RE: Comments on SEPA Review and Preliminary Plat Notice of Application  
- Currier Creek Estates Division 3 & 4 (LP-10-00002)

Date: August 4, 2010  
To: Mike Smith, Community Development Director  
From: Craig Jones, Engineering Tech. II *CJ*  
Through: Ryan Lyyski, City Engineer *RL*  
RE: Currier Creek Estates, phase 3 & 4 revisions

CURRIER CREEK ESTATES - DIV. 3 & 4
 PART OF SECTIONS 27 & 28, T. 18 N., R. 18 E., W.M.
 KITTITAS COUNTY, WASHINGTON
 - PRELIMINARY PLAT -

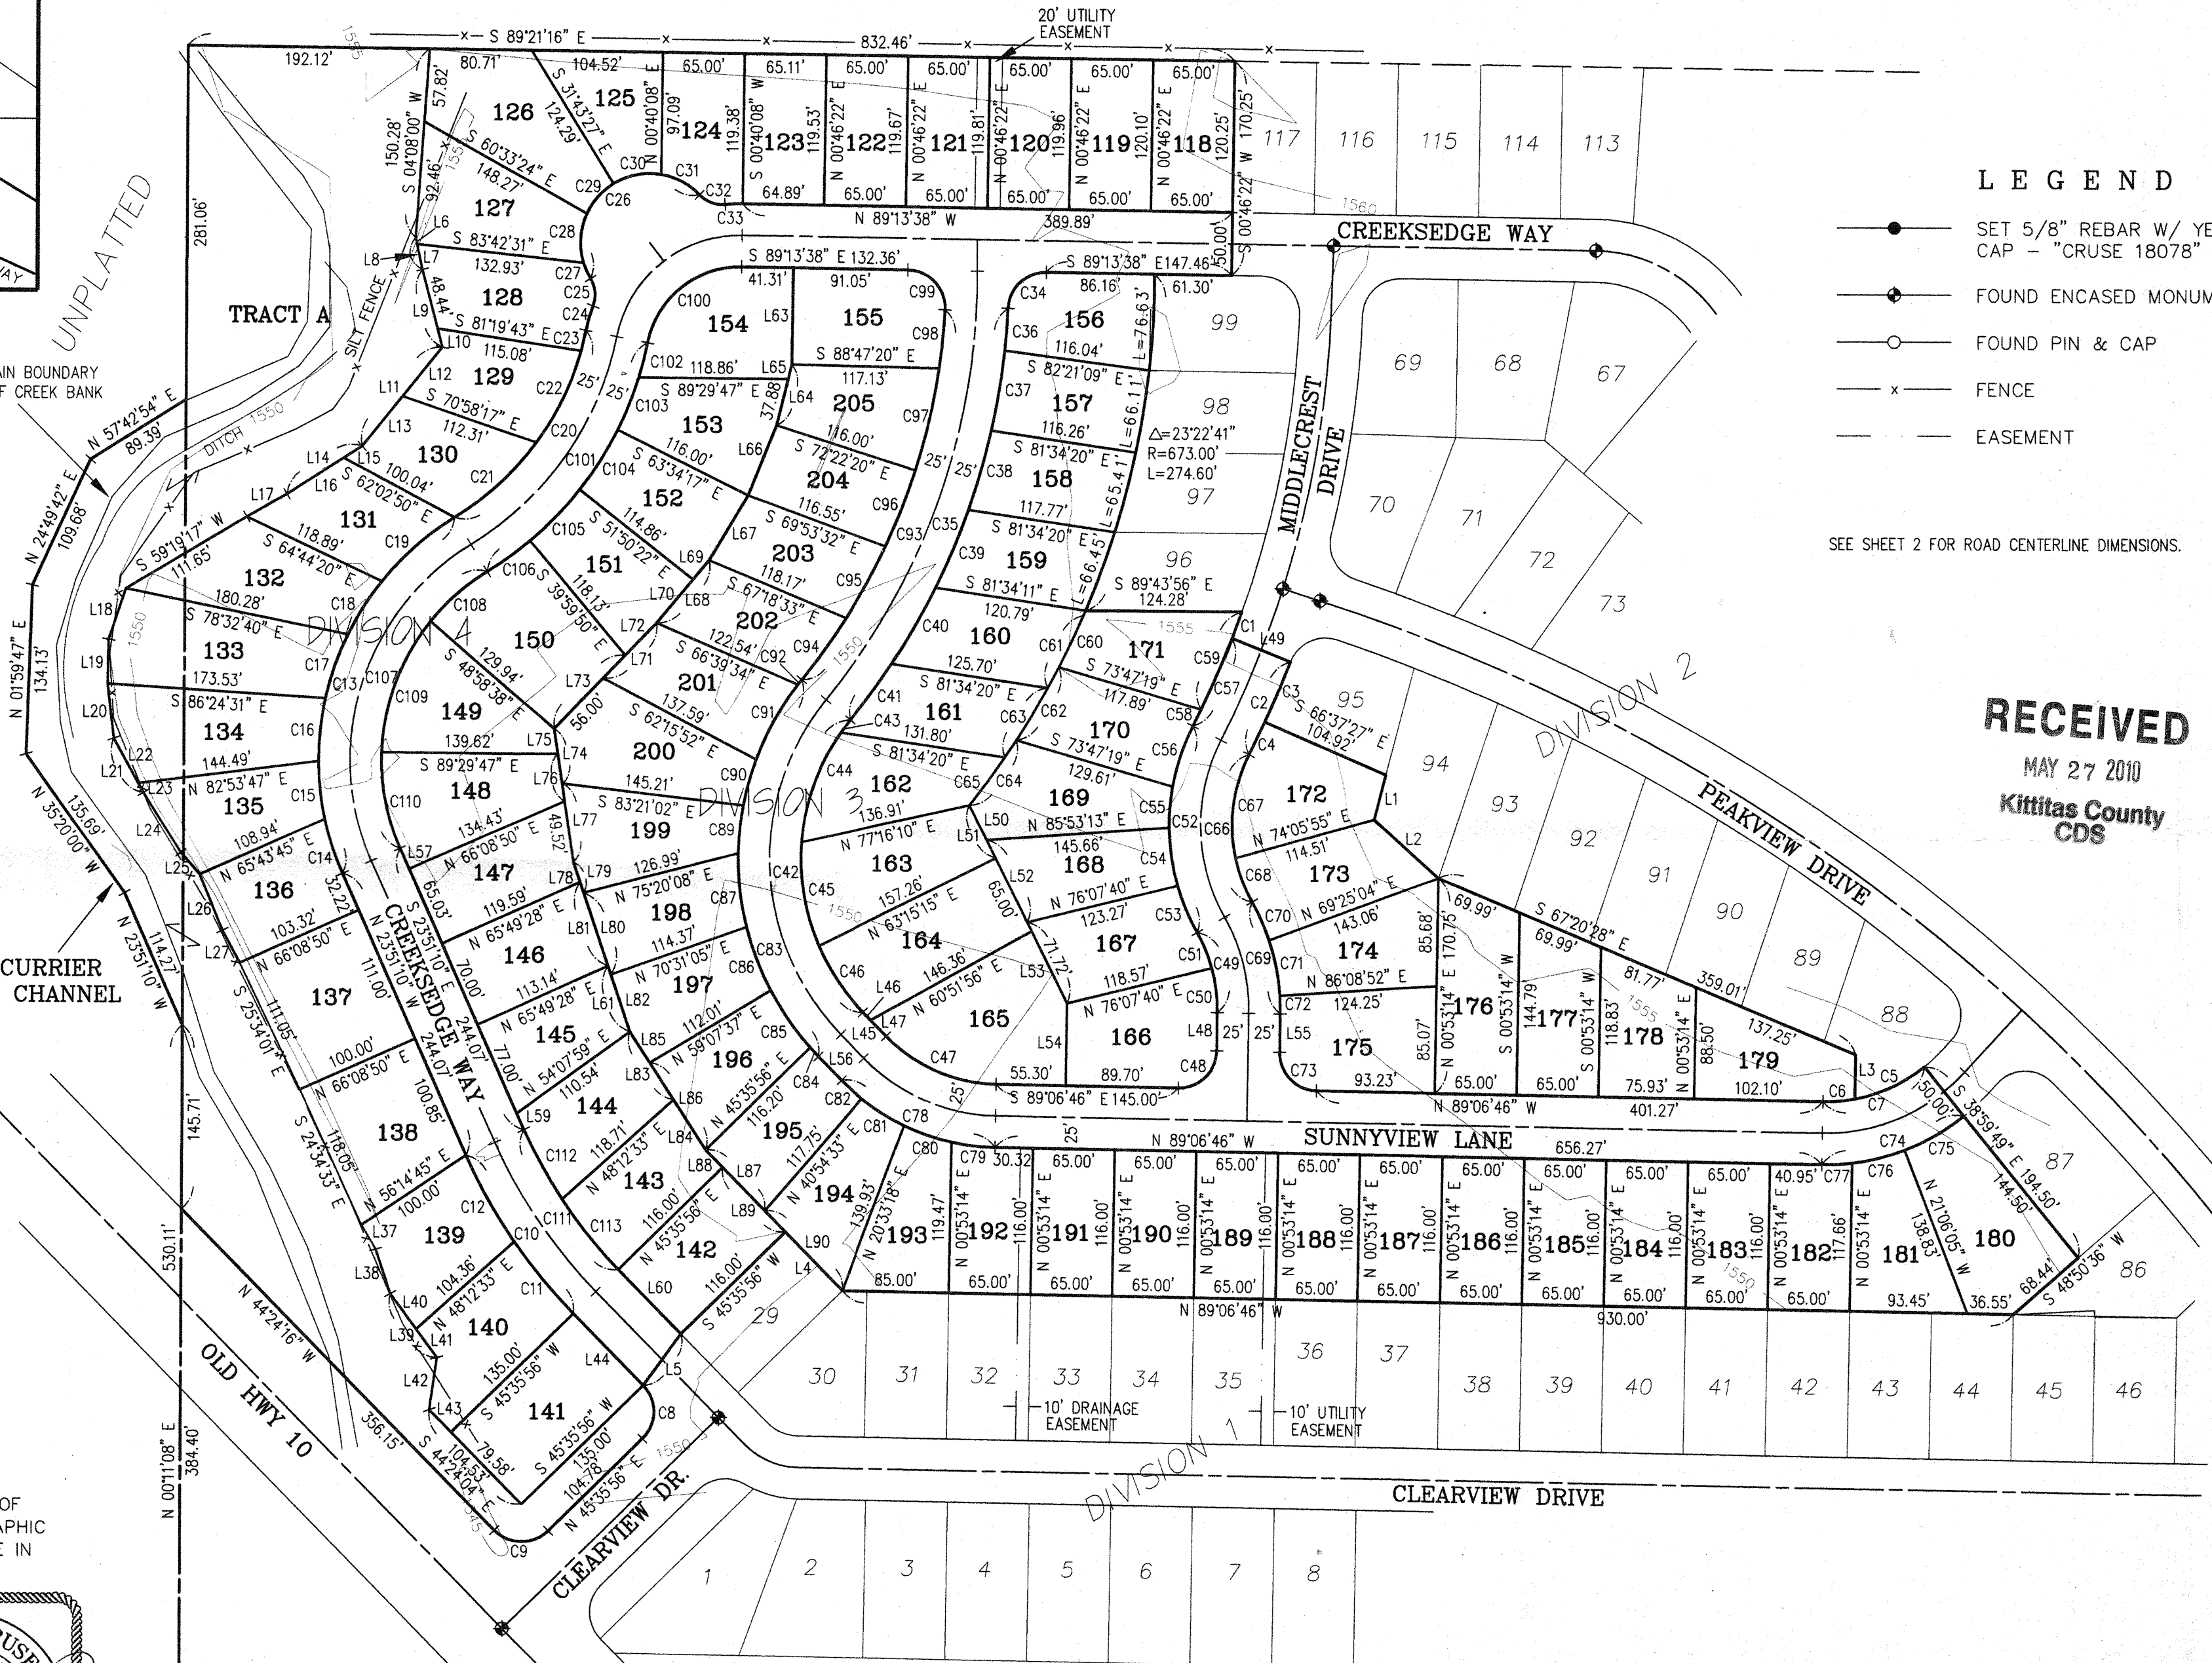
Recently the City adopted a new Critical Area Ordinance based on Best Available Science and the minimum buffer width for a stream such as Currier Creek is 85-feet from ordinary high water mark. It is not possible to get a clear measurement of the proposed buffer as represented on the preliminary plat drawings provided with this SEPA Checklist and the City would recommend that a minimum 85-foot buffer be imposed from ordinary high water mark of Currier Creek, that signage be placed at intervals along that buffer advising that it is a critical area and should not be disturbed without first consulting with the County Planning Department, and that the buffer be clearly denoted on the face of the final plat with clear reference that it is a critical area buffer and is not to be disturbed without first consulting with the appropriate agency.

The water and gas stubs on Sunnyview Lane need to be verified that they extend to the far south of lots 155 & 156 and out of the required road improvements.

The approved civil plans show the sewer main is to be built in Sunnyview Lane to serve lots 118 – 123, 155 & 156 and the rest of the lots along Sunnyview Lane in phase 3. An easement will need to be created for the sewer line that needs to be built through the future phase 3, until such time that right of way is dedicated.

The storm design on the approved civil drawings has a system that collects water from Creeksedge Way and conveys it down Sunnyview Lane. The storm system will need to be constructed with an easement granted, until such time that right of way is dedicated or an approved engineer can redesign the storm system and create a temporary system until phase 3 is constructed.

There is also a sewer line that was constructed as part of phase 2 that runs down Middlecrest Drive and through a portion of phase 3. There will need to be an easement granted for the sewer line, until such time that right of way is dedicated.
